**JOHN & HILDE GERATHY
34/10 LINCOLN CR WOOLLOOMOOLOO 2011
OWNERS**

**Development Application / EIS— SSD 6471
Submission re SYDNEY MODERN (SM)**

Final Submission – 14 May 2018

1 Section AA
Scale: 1 : 250

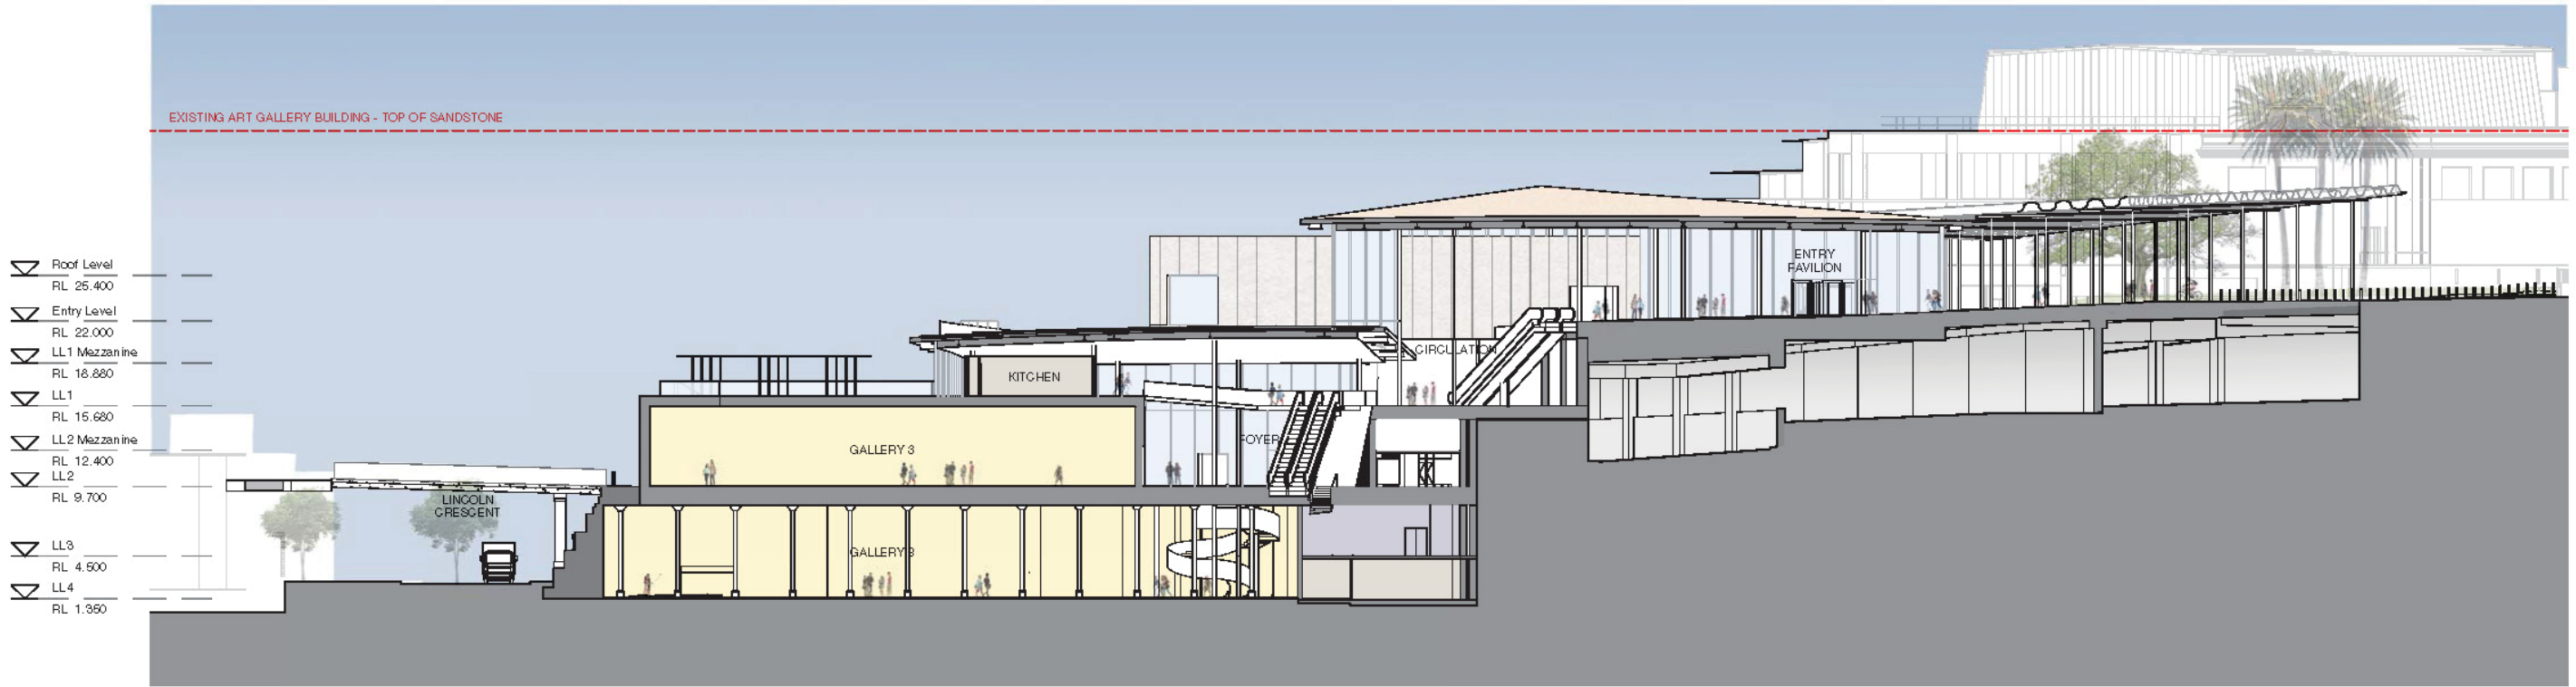
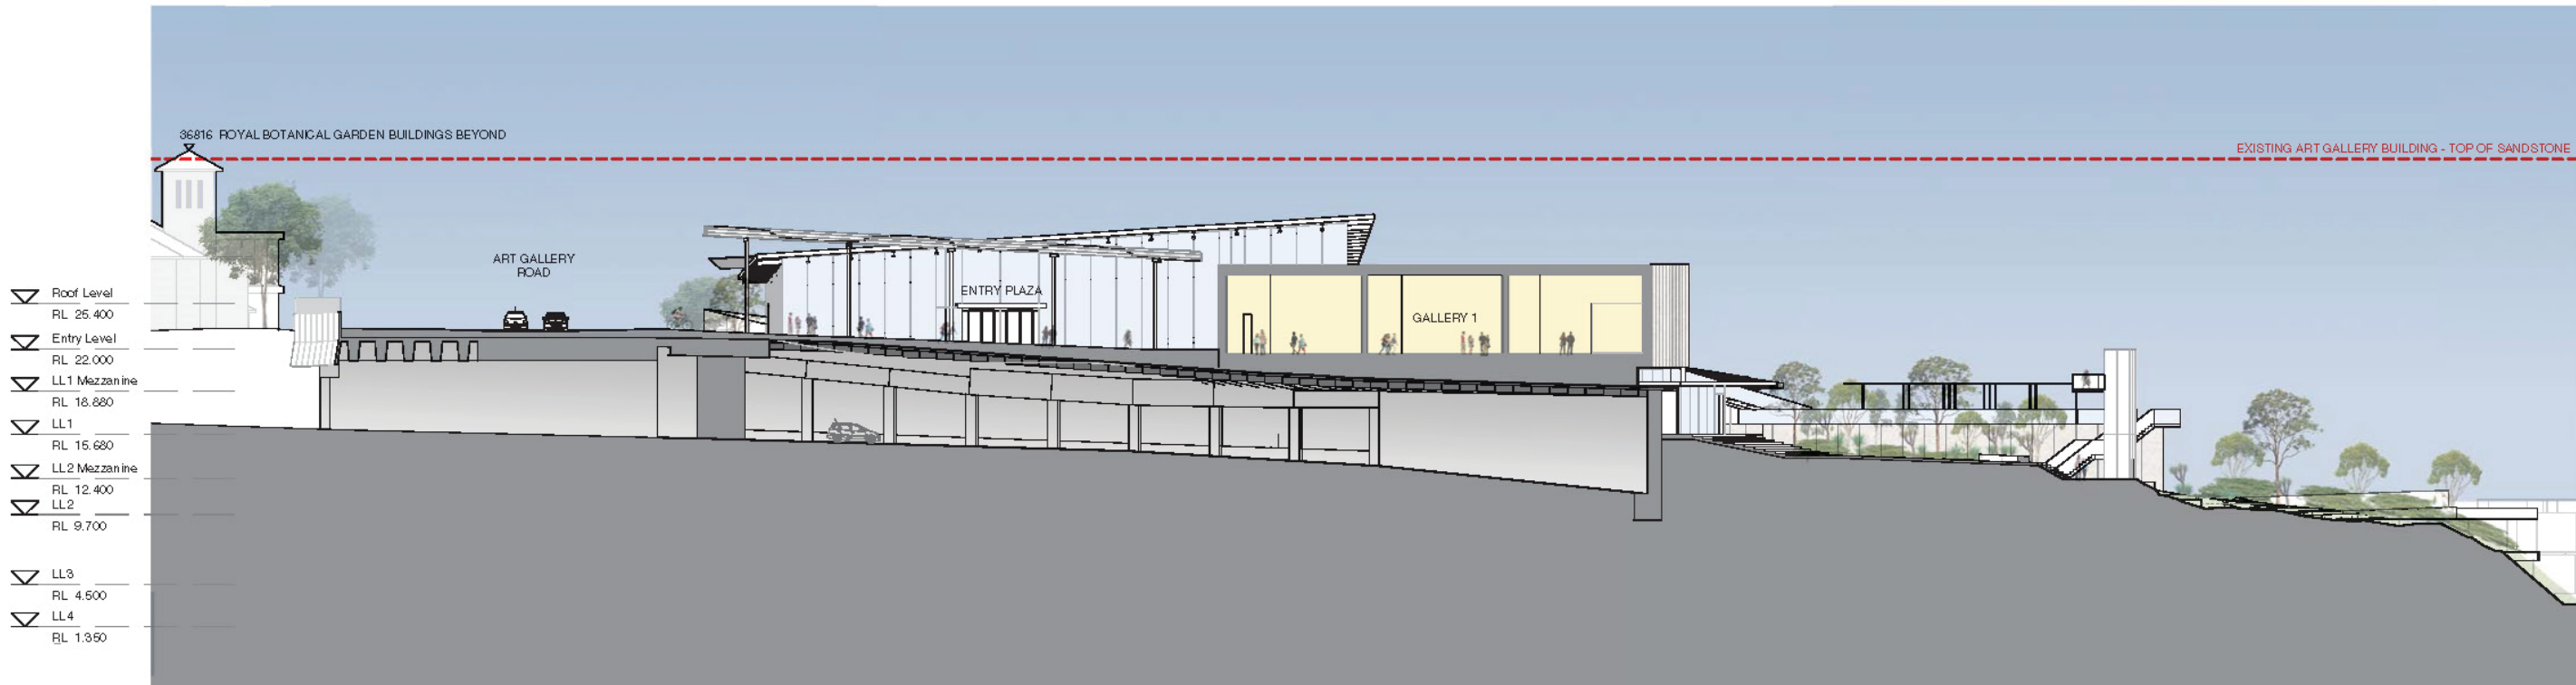
The siting of the lower Pavilion immediately above TWT on top of the existing industrial stepped naval concrete bunker wall will present a 14 metre (5 storey- refer attached Section Plan) solid concrete/ masonry 42-metre-long WALL right on Lincoln Cres without landscaping or architectural relief. There is a pavilion roof structure above the wall extending the height by another storey. This wall will create an overbearing canyon effect on entering Lincoln Cres when combined with the relatively robust western façade of TWT (albeit TWT is only two stories high).

drawing	East & West Elevations																																									
drawing no.	DA_3001																																									
Revision	C

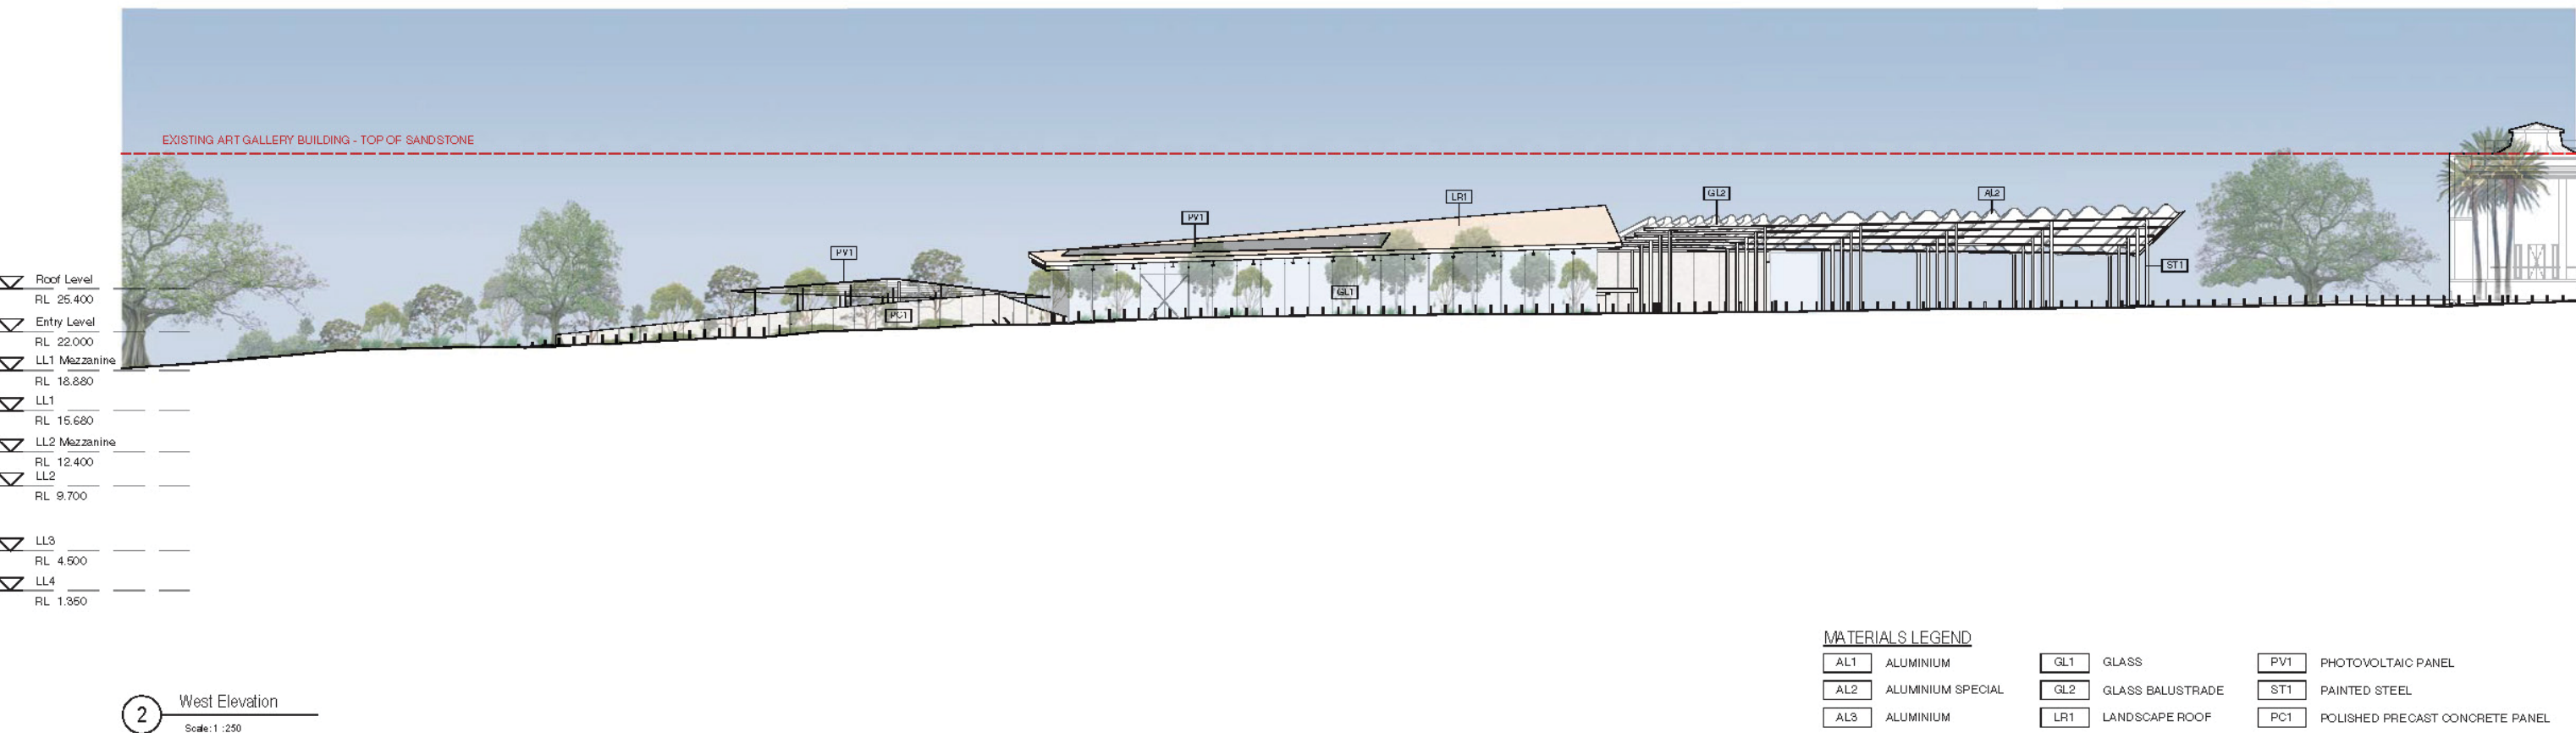
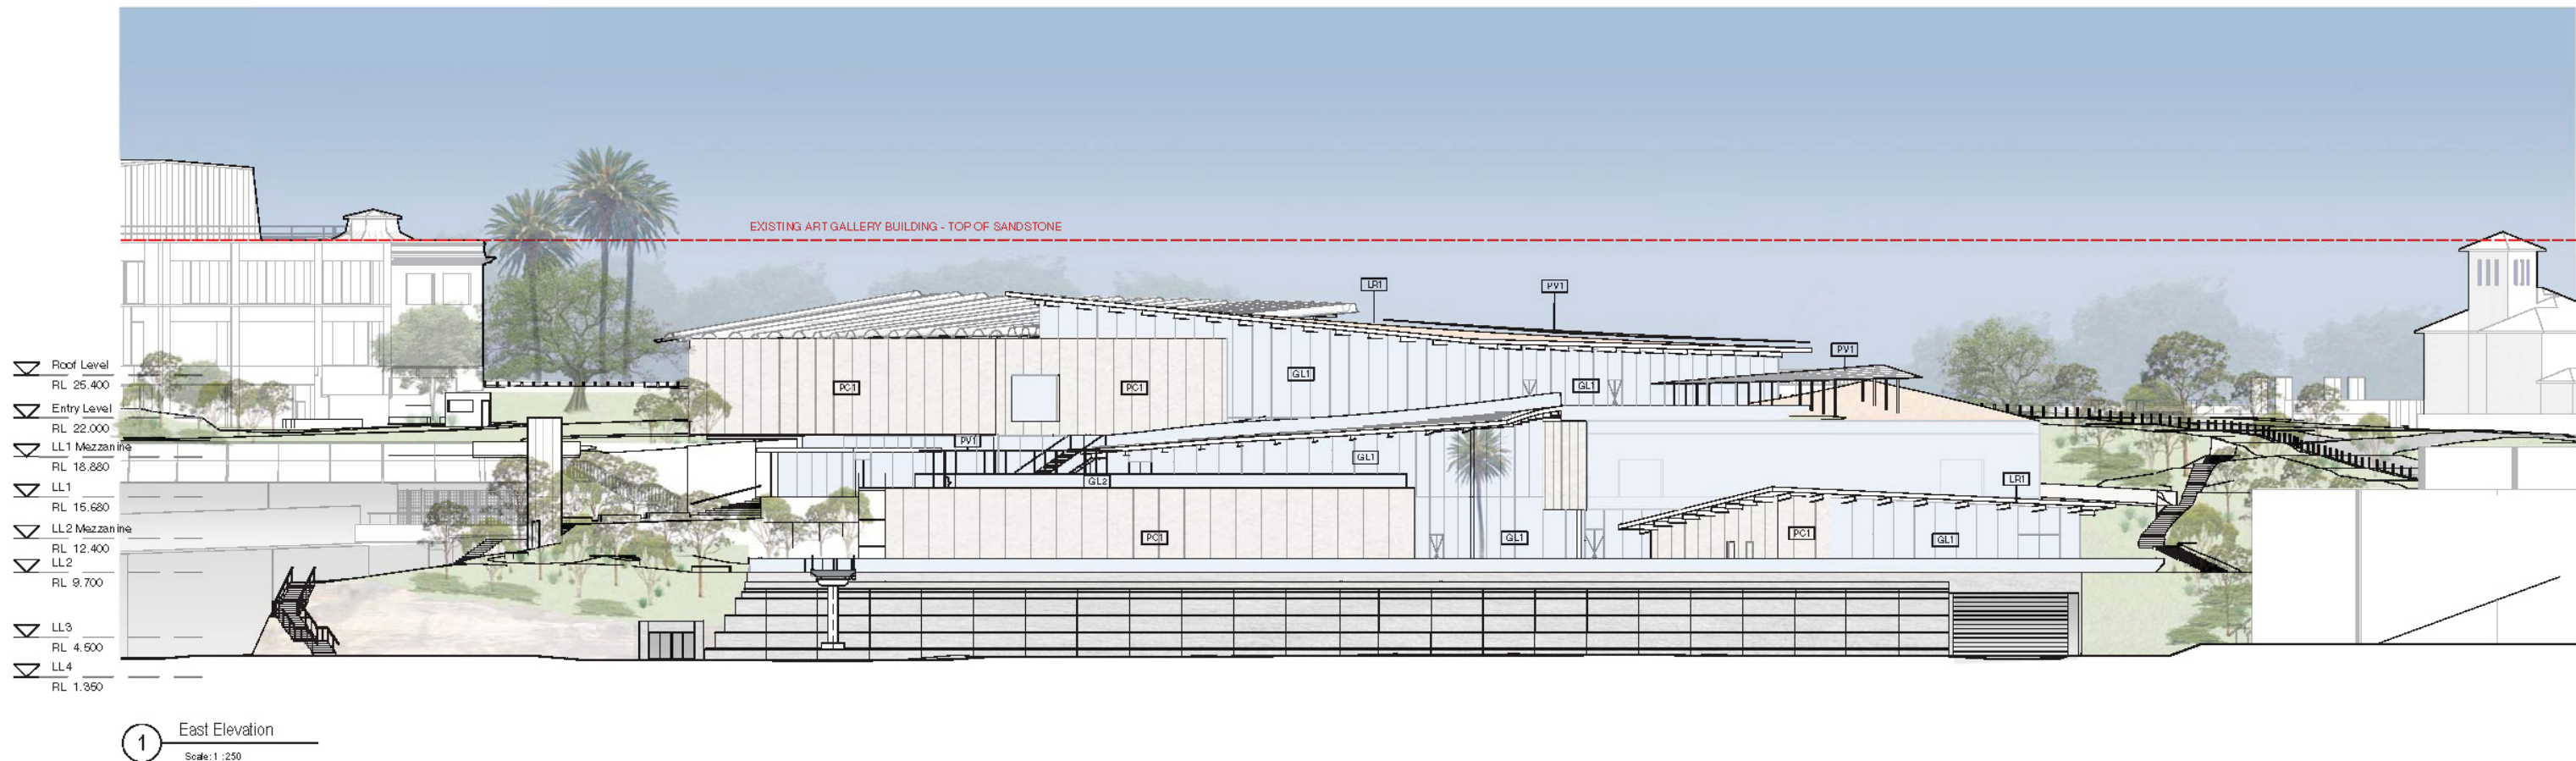
The lack of amenity of the eastern façade of the Lower Pavilion

The eastern wall of the Lower Pavilion, sited virtually on the top of the stepped wall, has NO RELIEF whatsoever.

It is suggested that this wall have vertical fenestrations (sheeted over internally if necessary for Gallery purposes) or similar trompe-l’oeil /architectural relief. It is, after all, a Modern Art Gallery!

Alternatively, or in addition the Pavilion could be set back 1.5 metres and a row of mature palms planted along it’s façade.

In the current plan nothing has been done to ameliorate the brutalistic industrial canyon effect along the length of Lincoln Cr. In fact, SM with the siting of the blank " limestone " Gallery 3 Wall immediately above the Bunker Wall exacerbates this effect.
